Net Zero Teesside Project

The Net Zero Teesside Order

Document Reference: 9.48 Applicants' Comments on Deadline 11 Submissions

Date: November 2022

Bedrock and Faults Map - Slice B

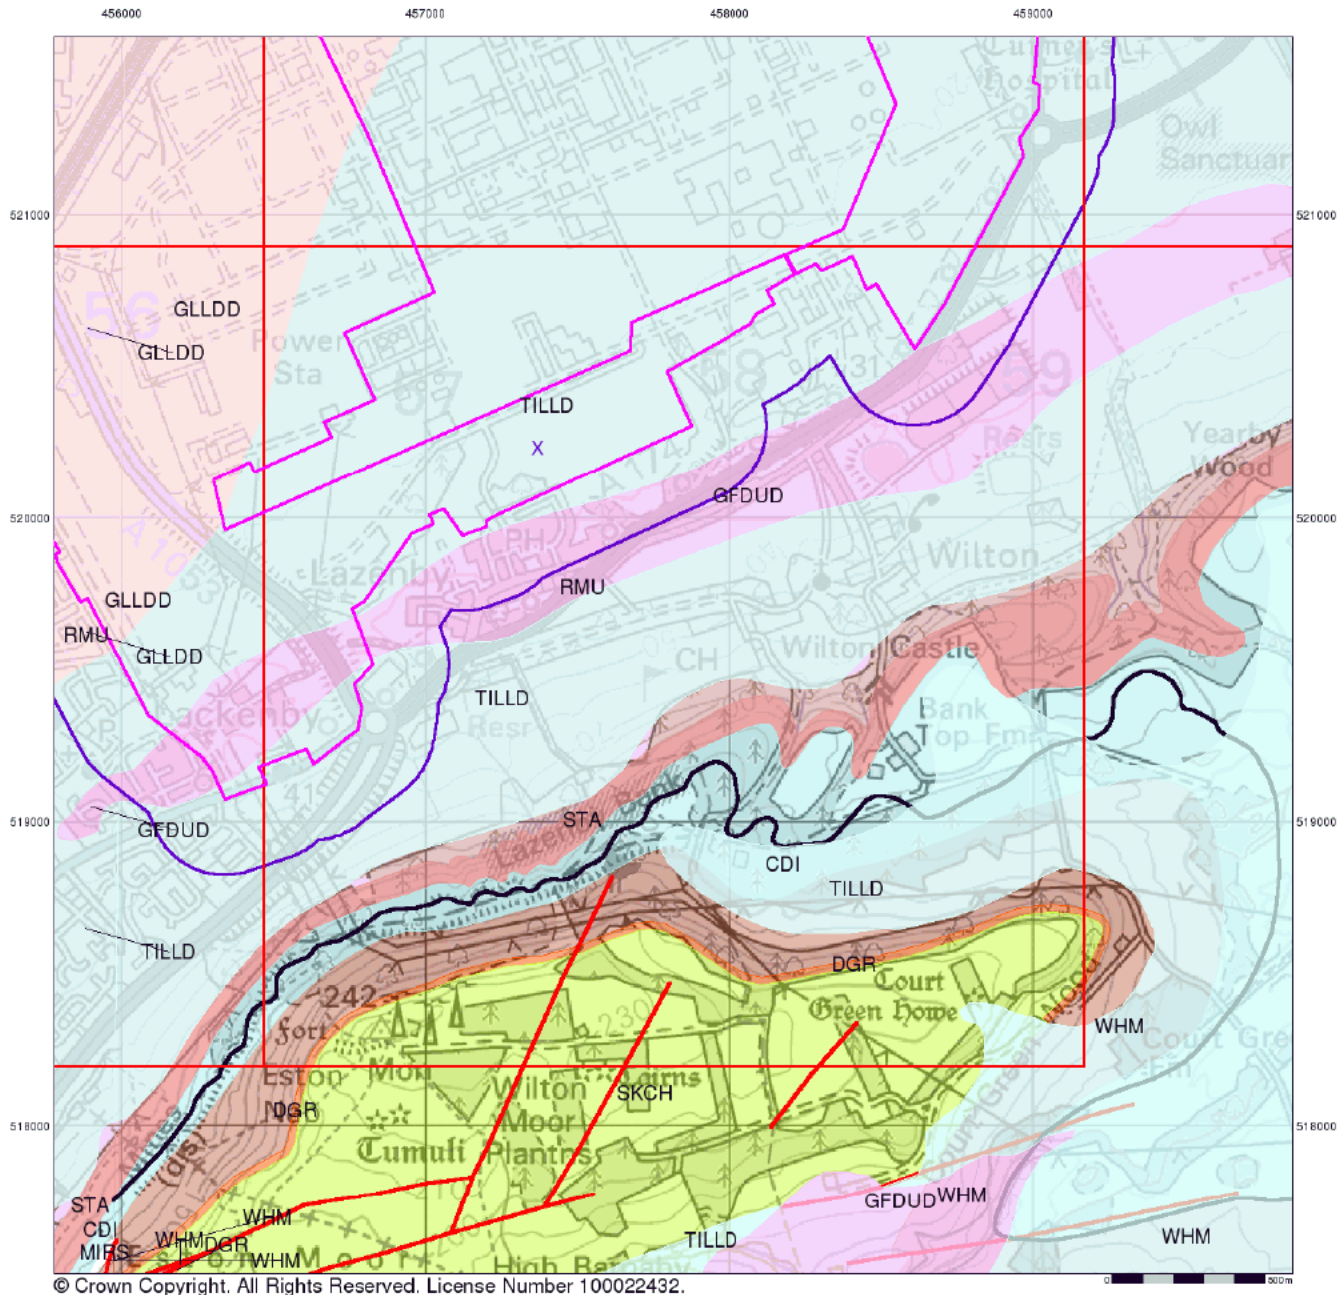
5.2.6 Deadline 8 Submission - 6.3.43 - ES Vol II Figure 10-17 Bedrock Aquifer [REP8-027] One of the designations for the aquifer is missing. The Applicants have submitted an updated version of this figure at Deadline 12 with the designations complete as part of the change request.
